Your Ref: OWPC25734
Our Ref: PO/1/20/HH 21-01-2020
Please ask for:
Zac Denton

Retention of car port to side elevation & raised roof to existing garage.
9 Arundel Road Poling

Proposed Front Elevation North

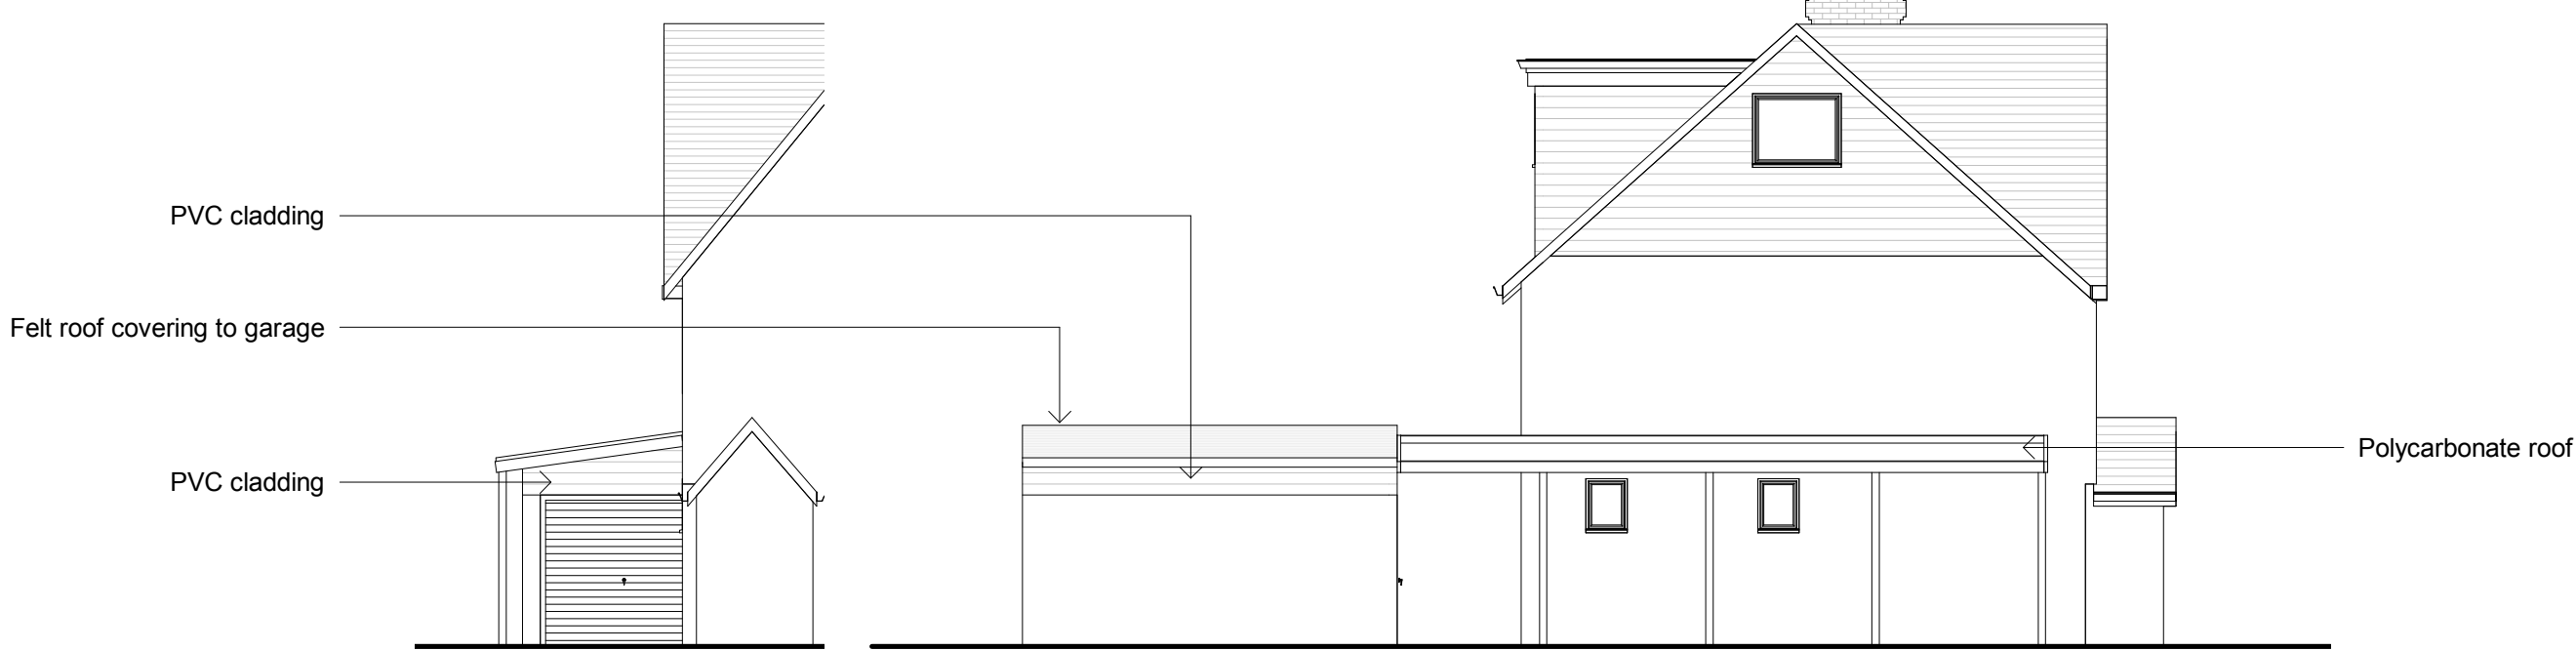
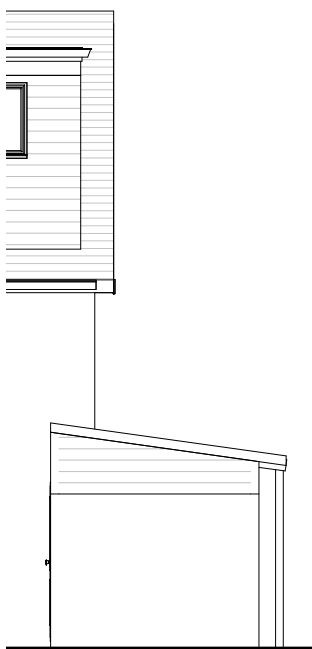
The current hight of the garage is blocking a significant amount of light more so in the summer months and getting little light on the side of our property . The work that we have had on our house is to be eco and was told light is very important in a home.
